RE: Water Resources Report
Rapson Subdivision – EPC Parcel #5112000007
Comments on Water Quality, Water Resources, and Wastewater Disposal Report
Response to comments

Colorado Division of Water Resources – Letter of Denial – April 6, 2021

El Paso County Planning Comments on Water Resource Report:

El Paso County Planning comments on Wastewater Disposal Report

C1 of 5

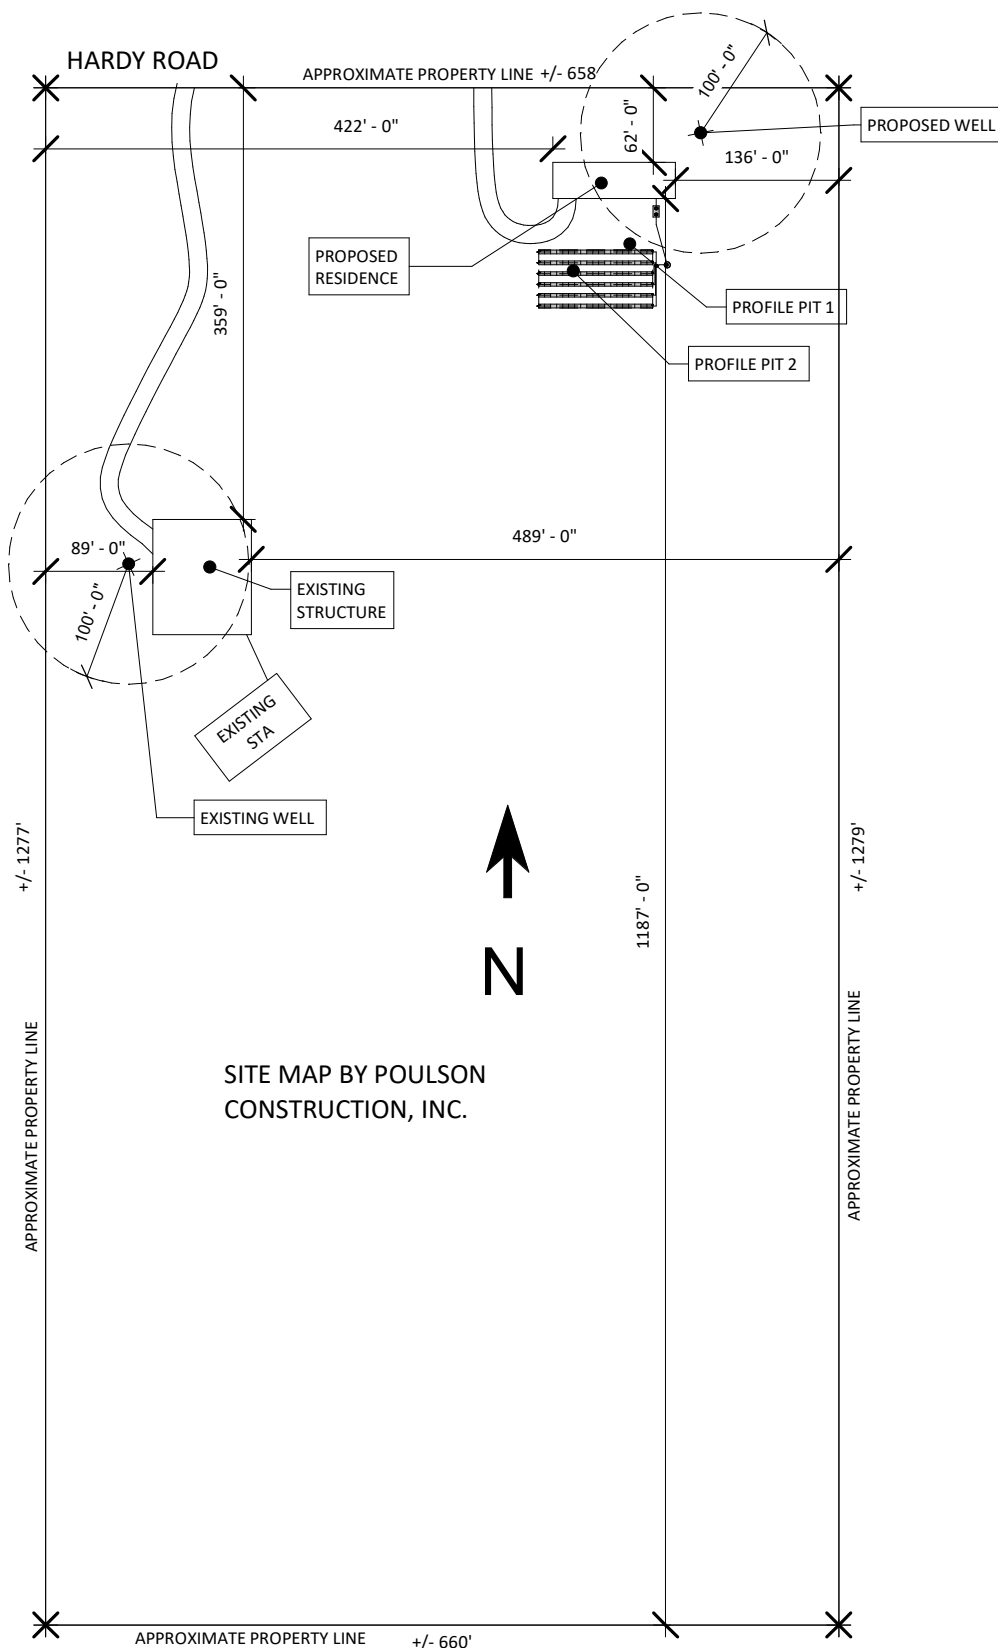
- 1) Comment: Show both proposed wells on Map C1.

Response: Map C1 represents the proposed well and proposed septic system on lot #2. The other well exists on existing lot #1, which already has an existing well and existing septic system. See revised page C1 of 5 depicting both wells (existing well and proposed well).

C2 of 5

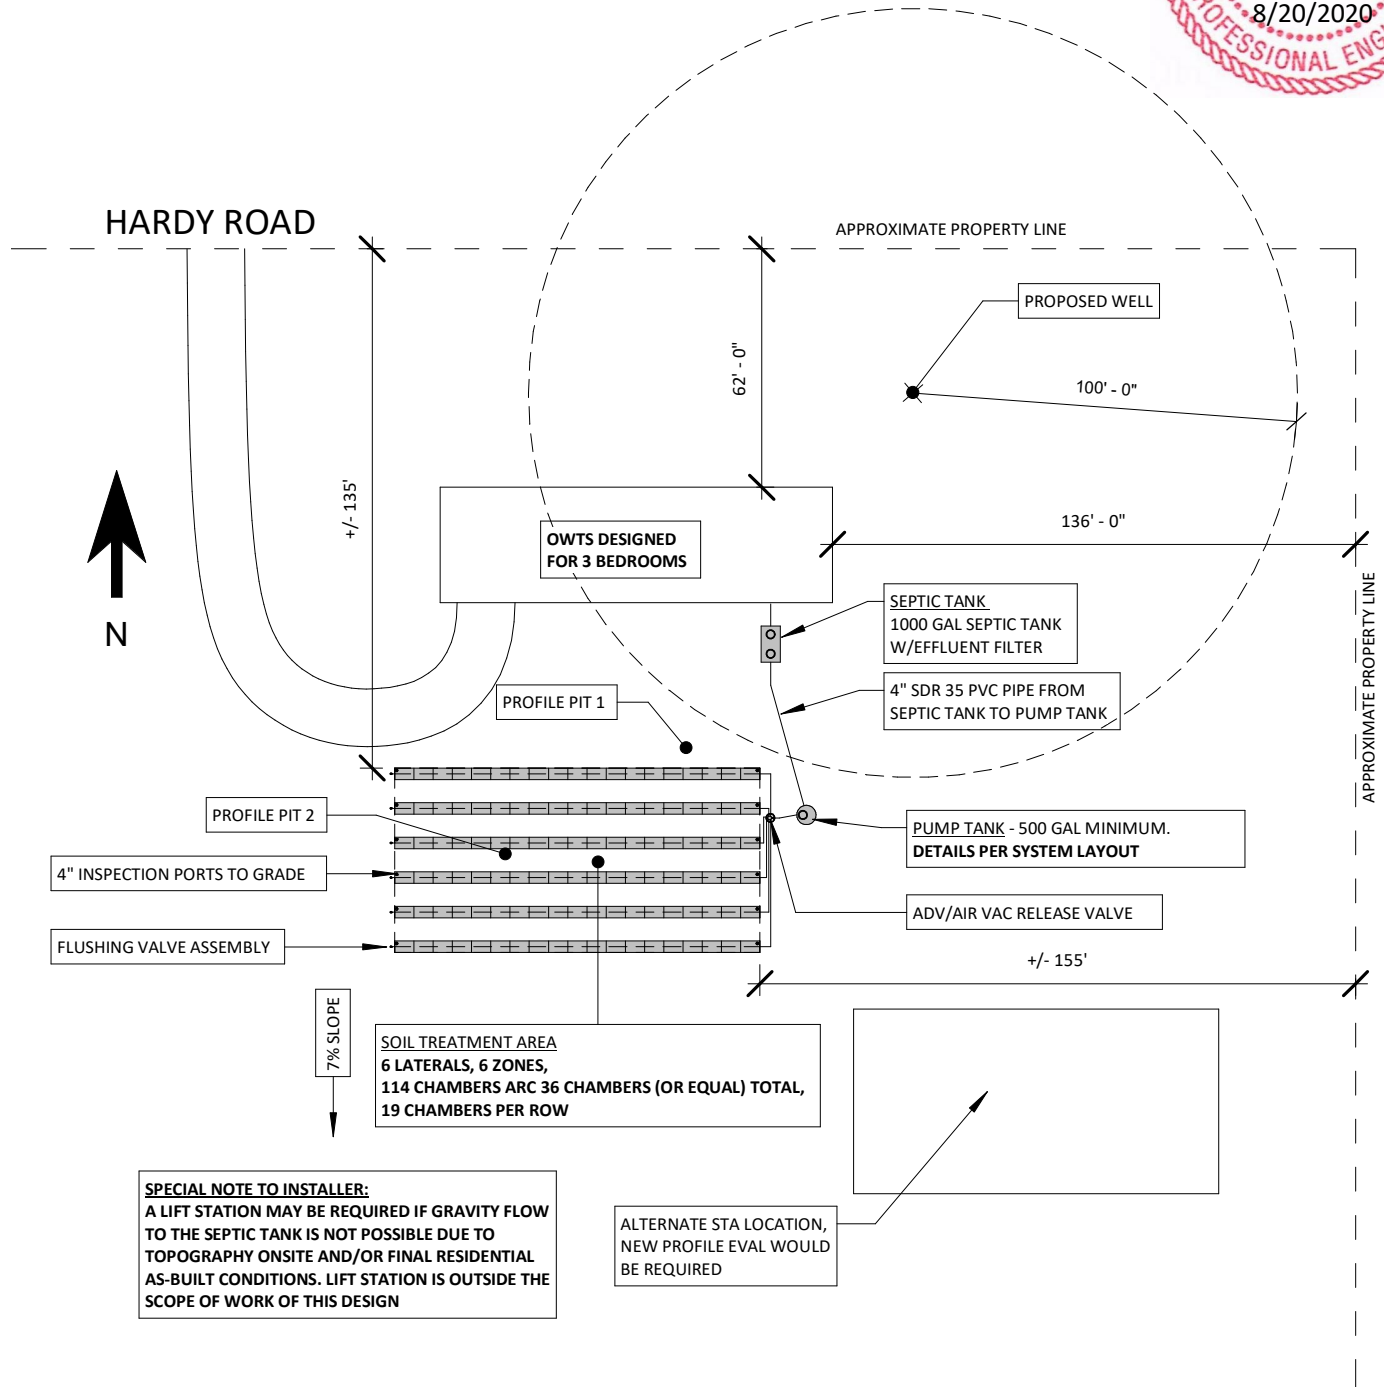
2) Comment: Include exhibit for existing residence as noted on Site Map, Sheet C2

Response: Revised Wastewater Disposal Report includes a set of five drawings from GeoQuest, LLC which depicts the existing septic system as constructed in March 2020. These drawings can be found at the end of the report.
